AQUIND INTERCONNECTOR

Consultation Report – Appendix 1.4Z
Statutory Consultation - Feedback from
Marine Stat and Non-Stat S42 Consultees

Document Ref: 5.1.4Z

DATE: 14 NOVEMBER 2019

TITLE:  
**Figure 3.5  
Indicative Seabed Preparation  
Sheet 1 of 4**

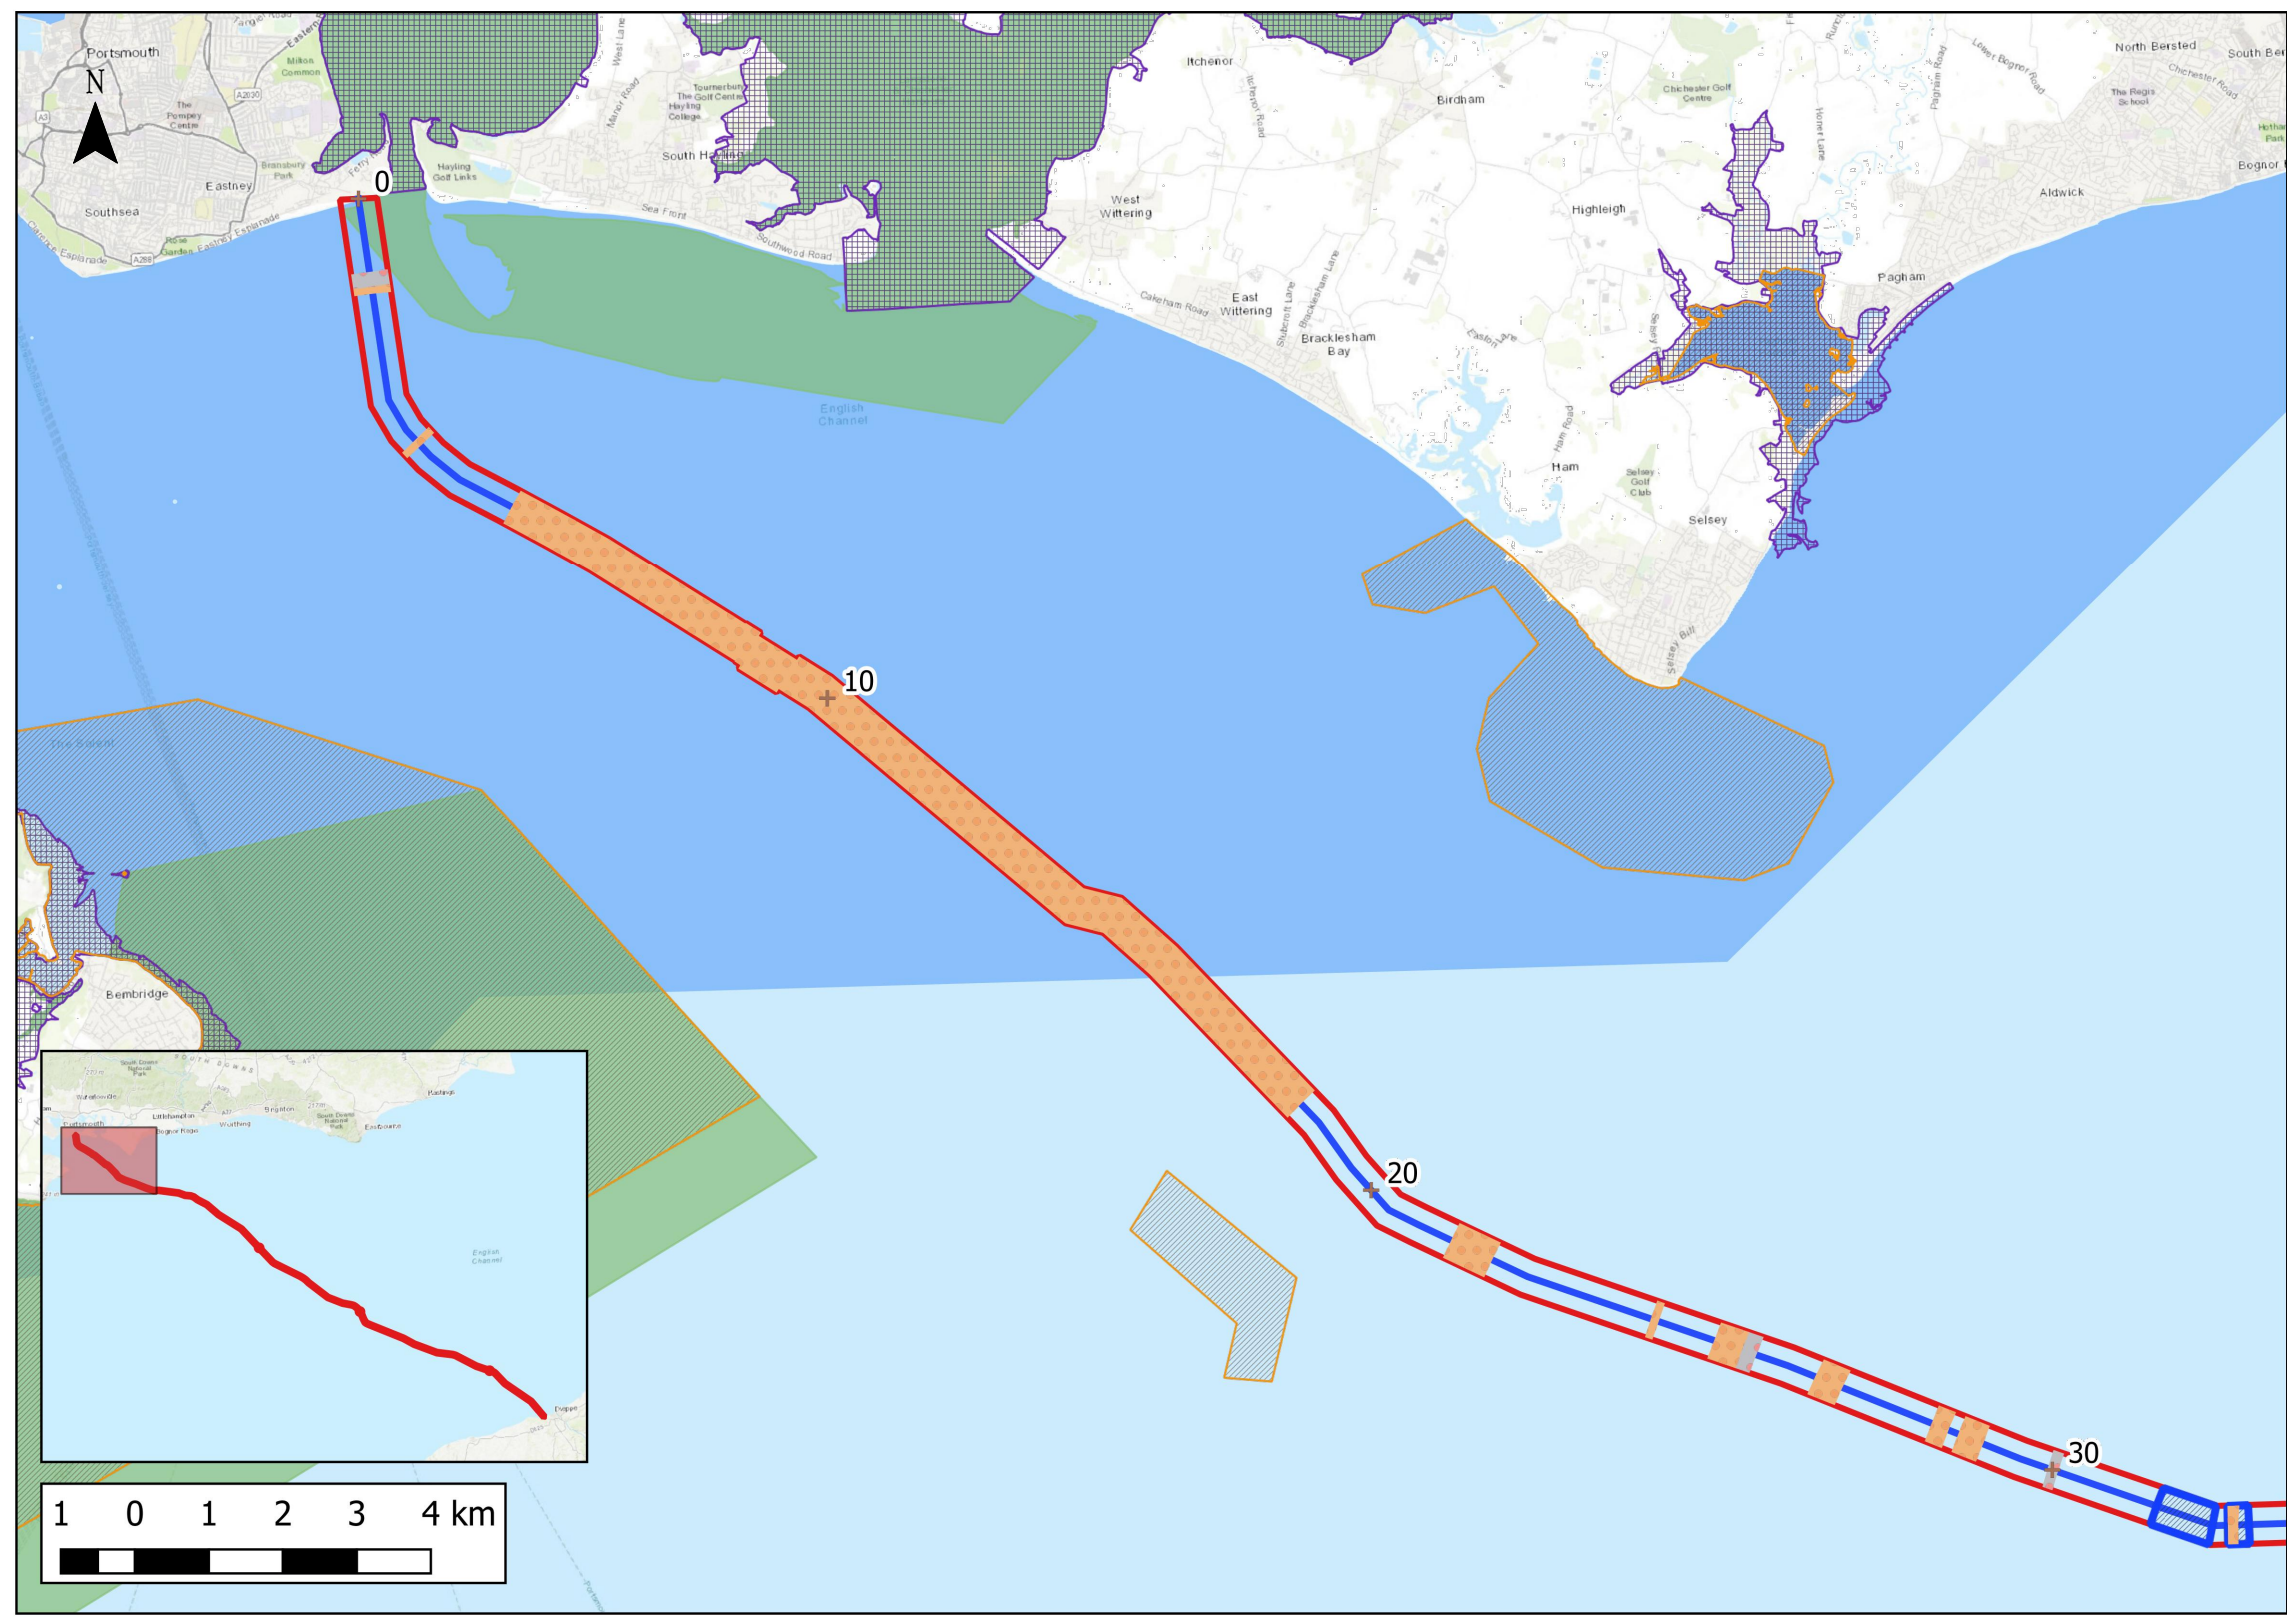
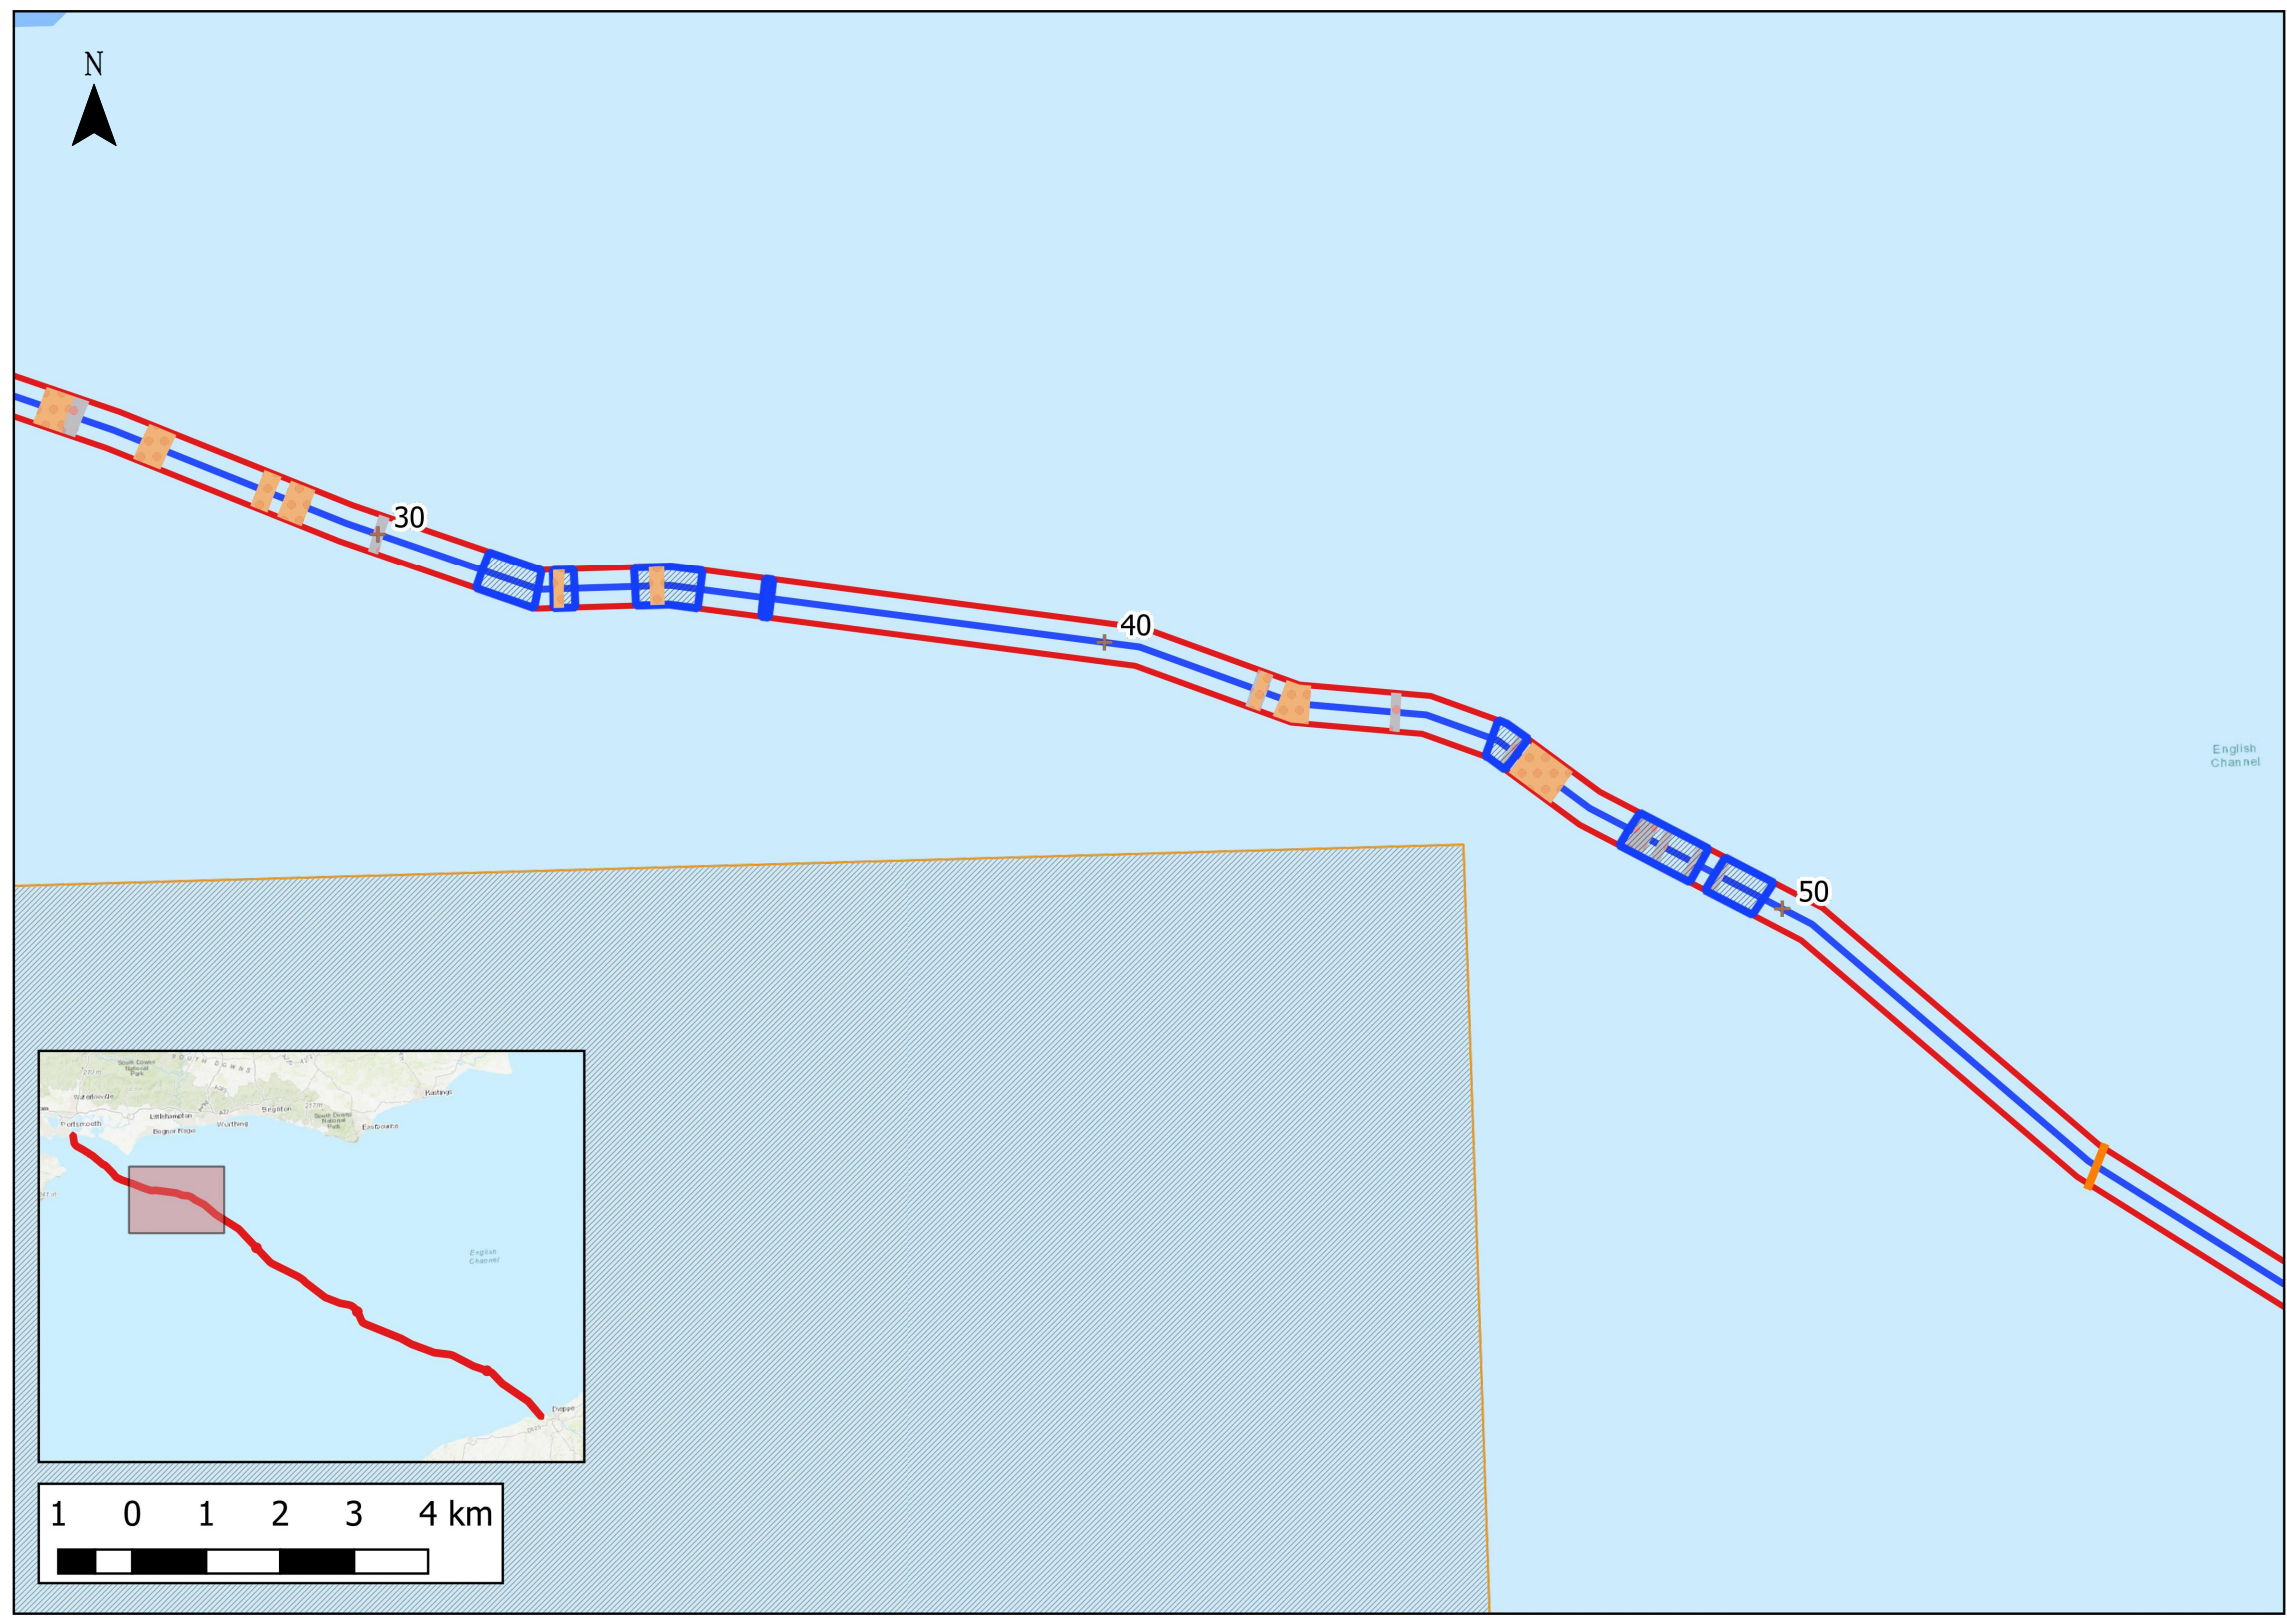
| Item | Topic | Natural England Comment |
|------|--|---|
| 23 | Intertidal and Benthic Ecology | Natural England advises that for the following figures: 3.3 (UK Landfall), 3.6 (UK Mobile Sediment) and 3.5 (Indicative Seabed Preparation), it would be beneficial to display nationally and international designated conservation sites for ease of reference. |
